From: Amanda Scholes on behalf of Planning.Responses
Sent: 31 May 2017 08:51
To: Planning Scanning
Subject: FW: Planning Consultation on: LU/121/17/RES

Comment from Greenspace

Registered: 19th April
2017
Site Address: Land North of Toddington Lane Parcel C1 & part
Parcels B2, B4 & C2 Littlehampton BN17 7PP
Grid Reference: 503051 103950
Description of Works: Approval of reserved matters following outline
consent LU/47/11/ for construction of 126 No.
dwellings together with internal road network, car
parking & landscaping.

Tree Planting Details LA108

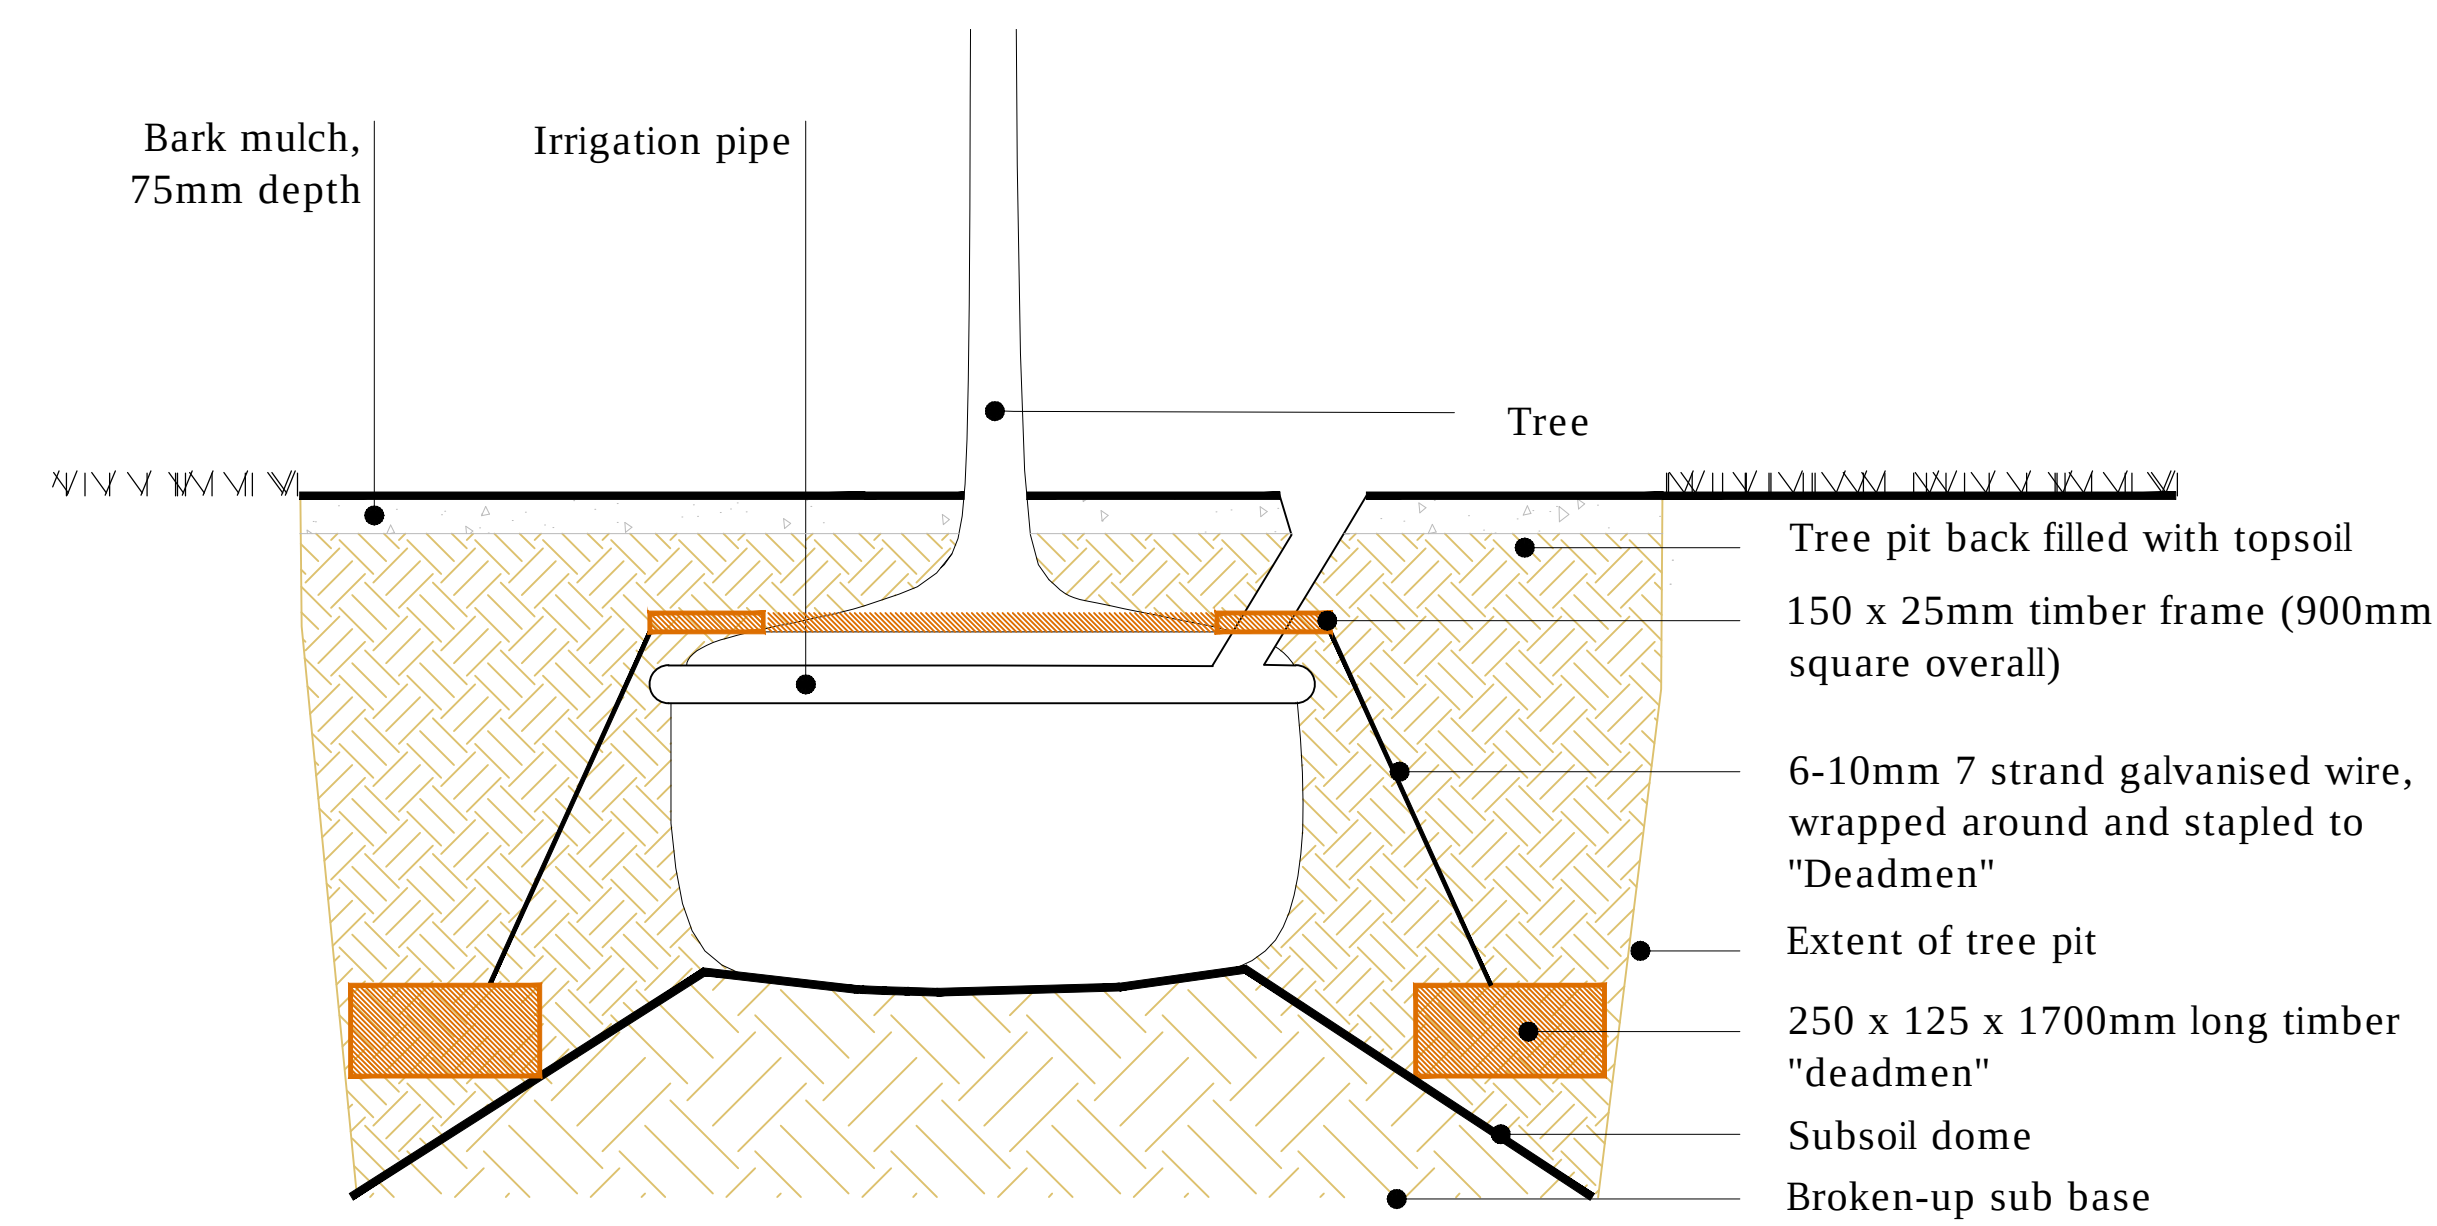
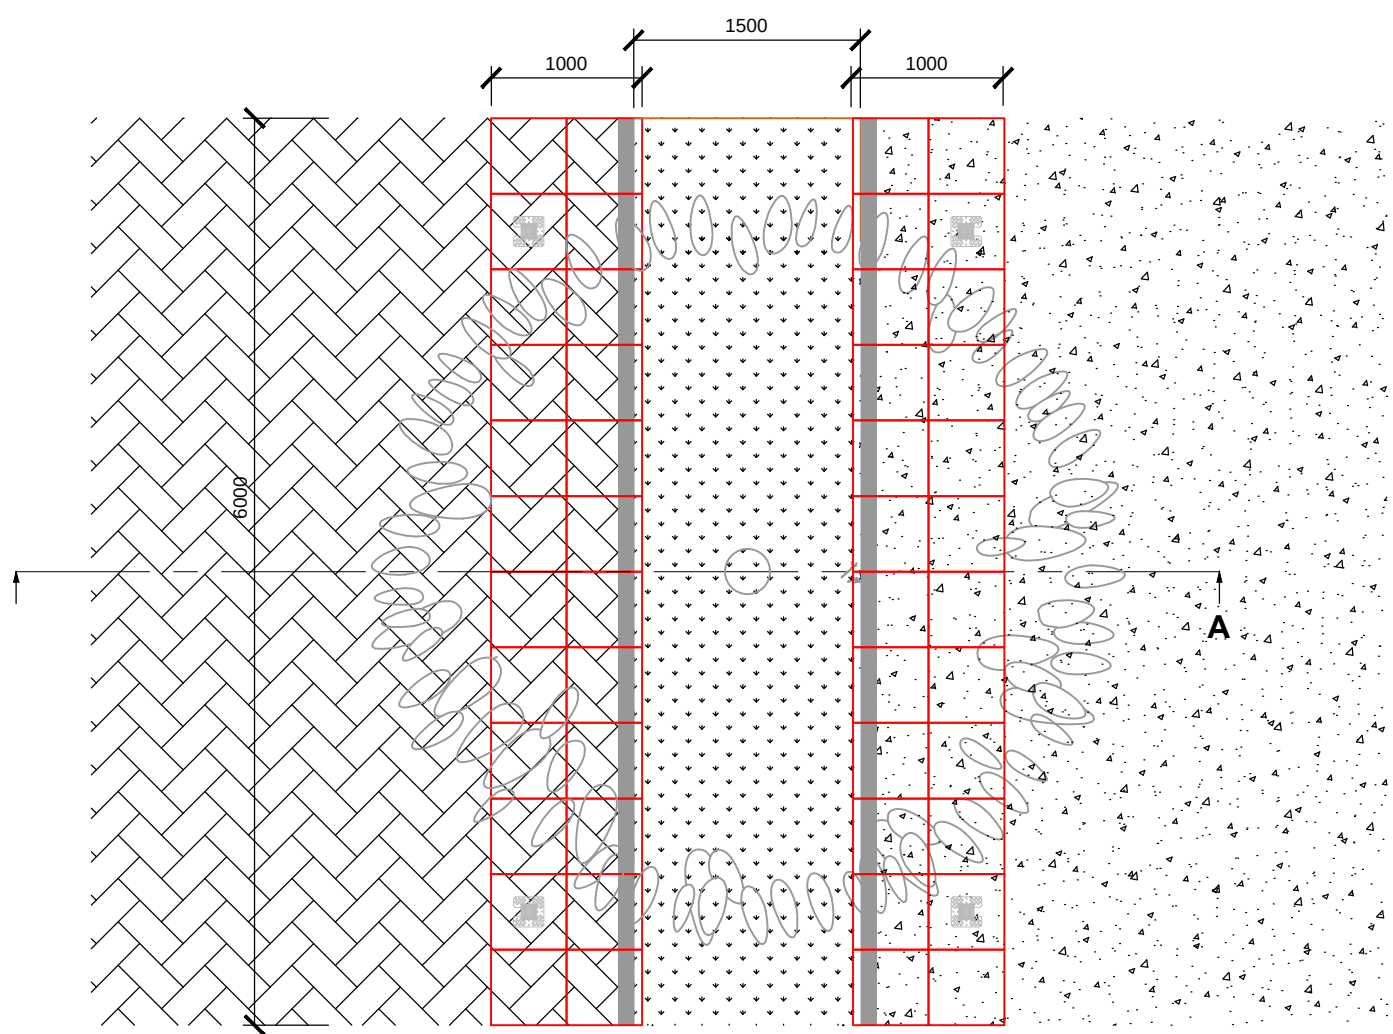
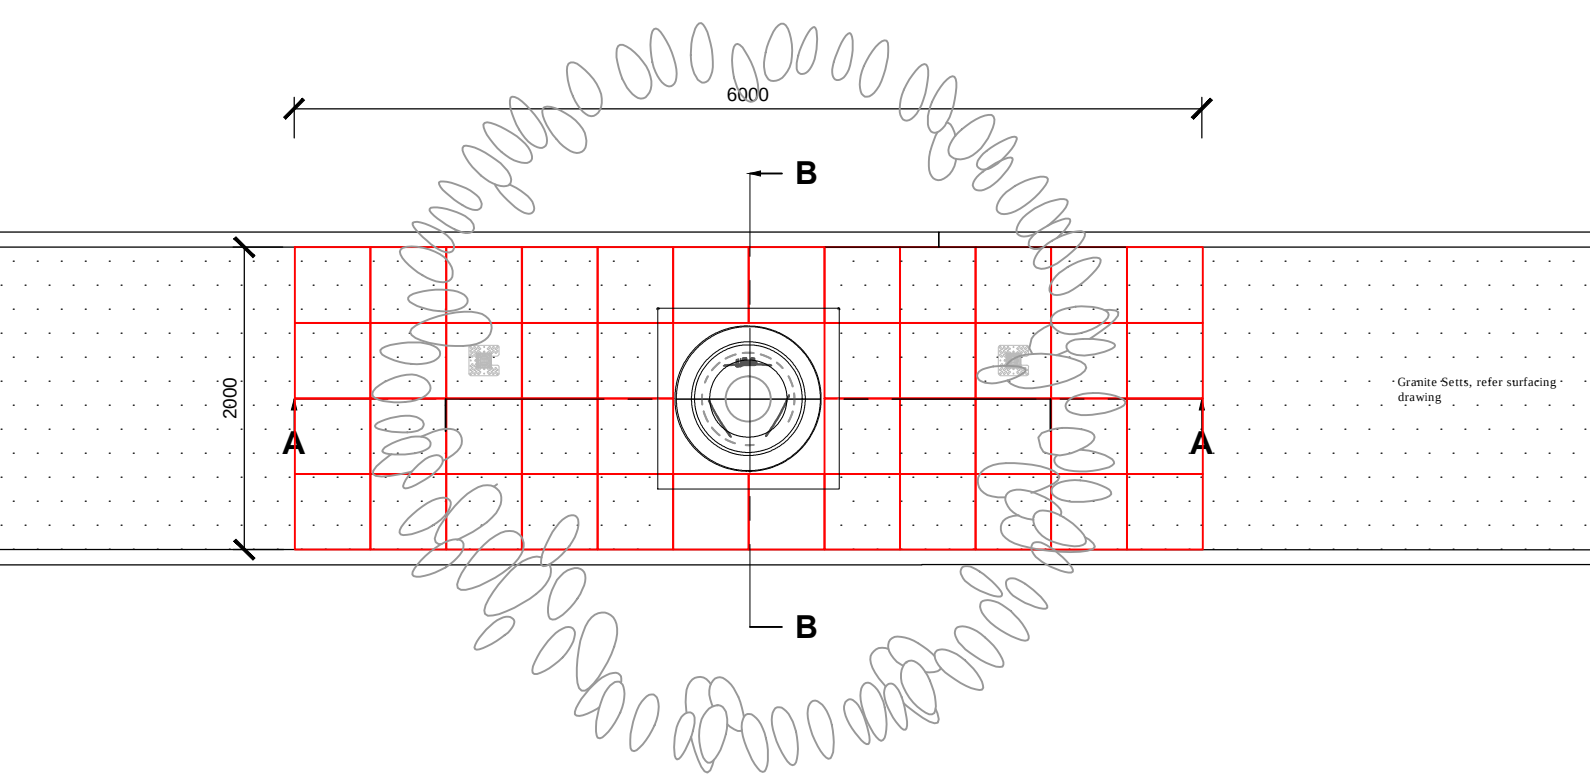
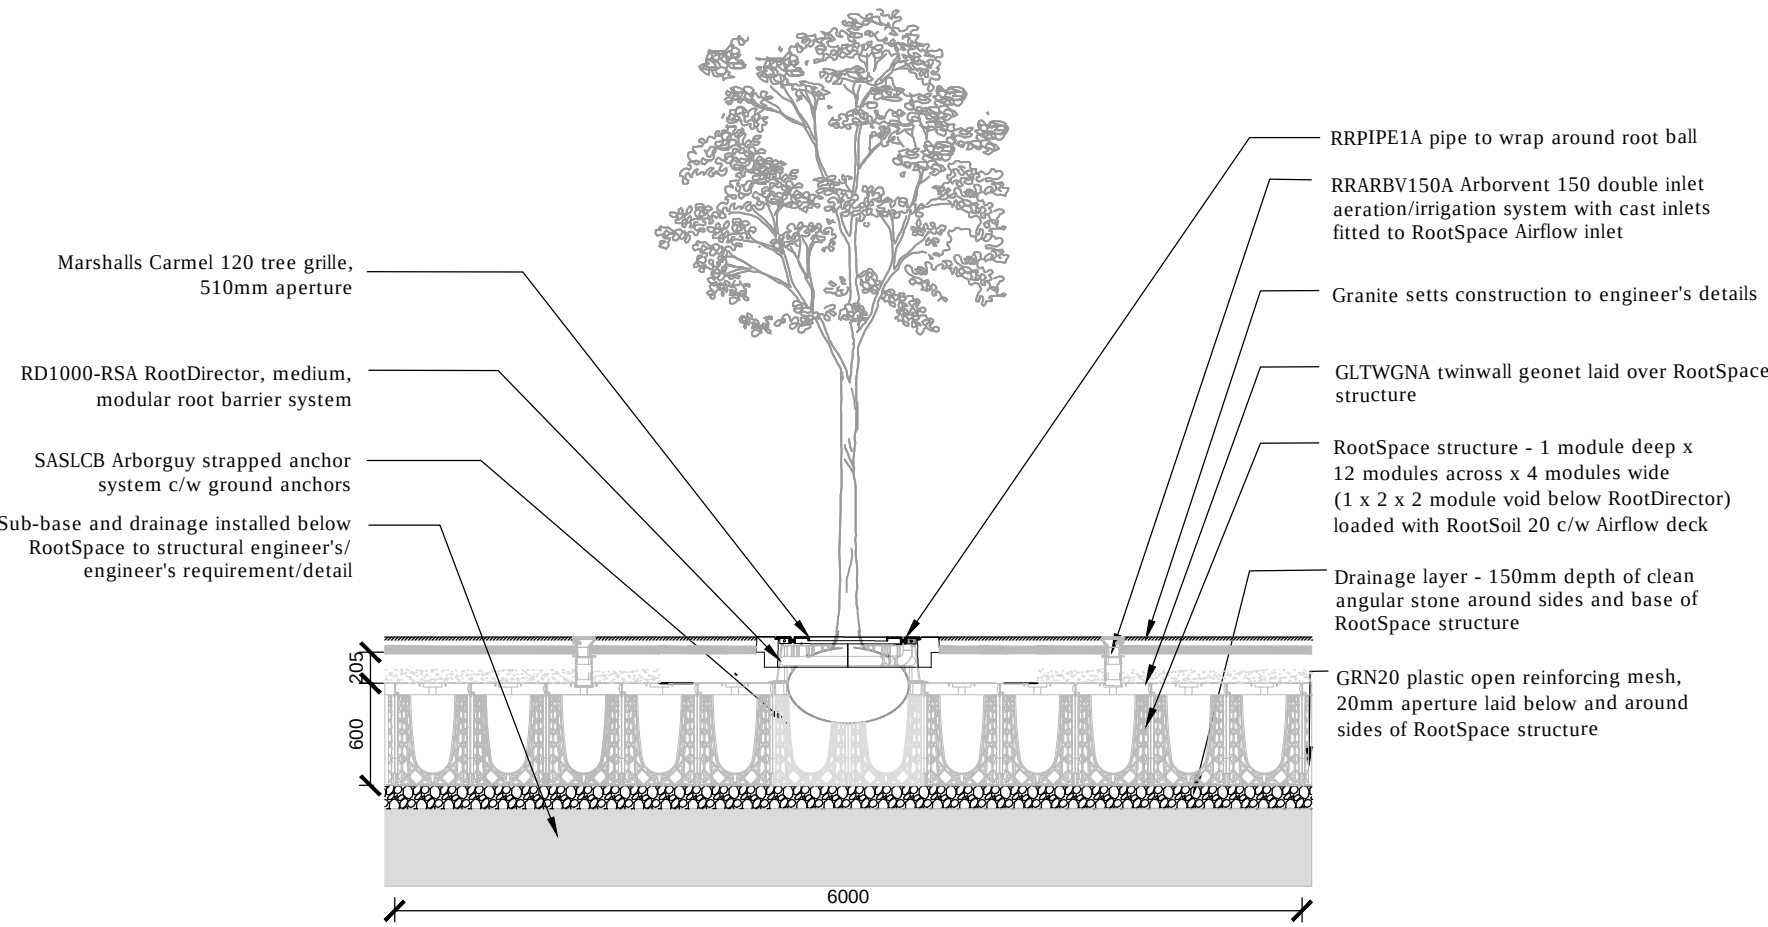
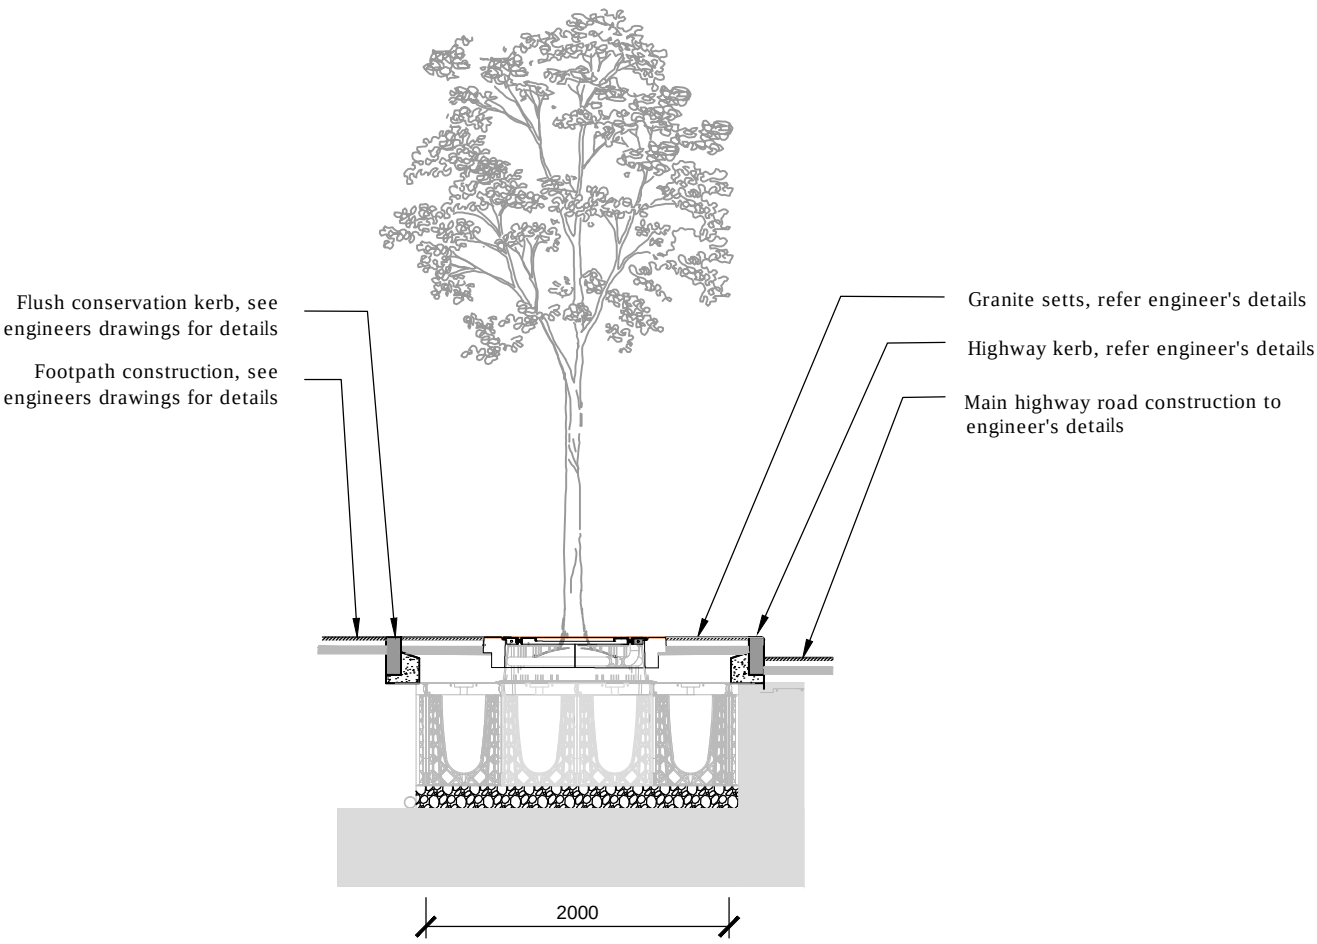
A planting pit formation cross section and specification would be requested for all trees and particularly for the proposed Betula to ensure that these have a viable rooting medium in which to support long term thriving growth and establishment.
